Planning Application BE/159/12

Re Two storey side extension at 24 Ashurst Close, North Bersted

BLOCK PLAN

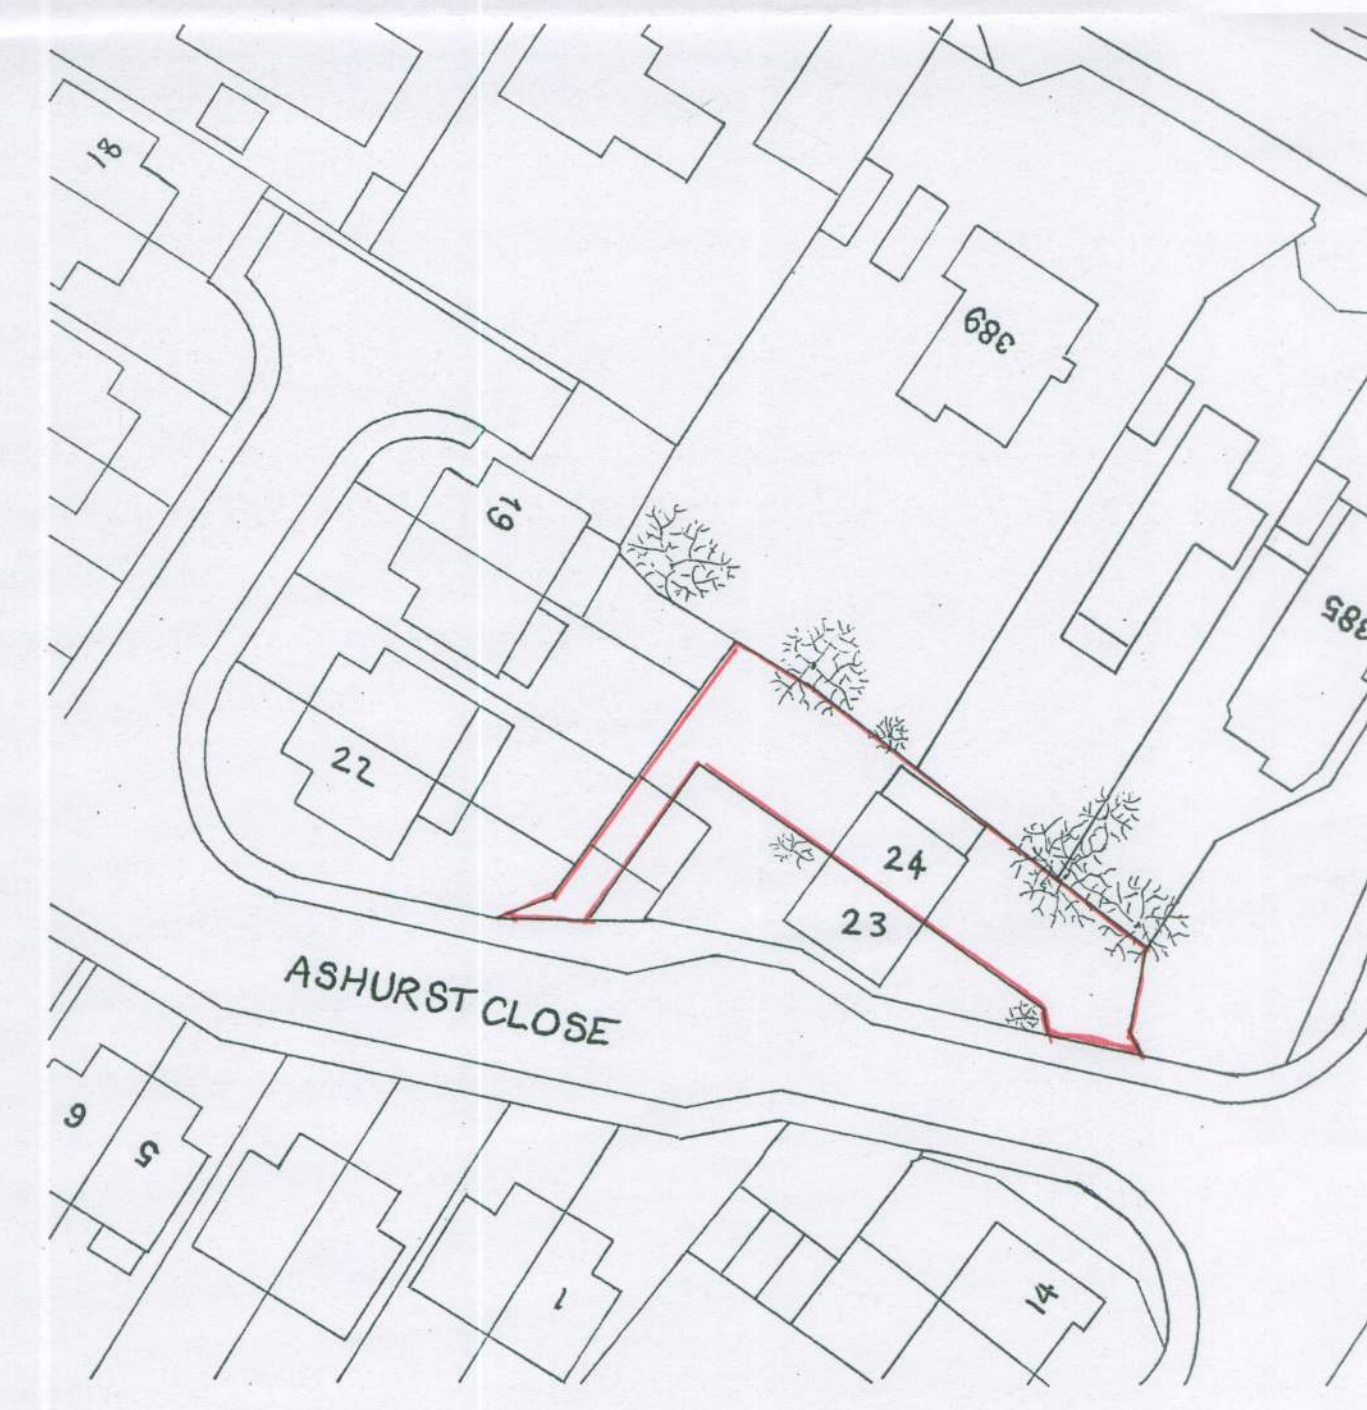
The Plans do not show what is and what will be nor any measurements.

Two metres from the new build is quite a distance and will of necessity site the fence on what I consider to be my garden.

I would be grateful if you could advise me where this new fence is to be erected.

What measurements have been taken to calculate that siting and have those measurements been confirmed by you?

Does this 'new' boundary impact on both bungalows at 387 and 385 Chichester Road?
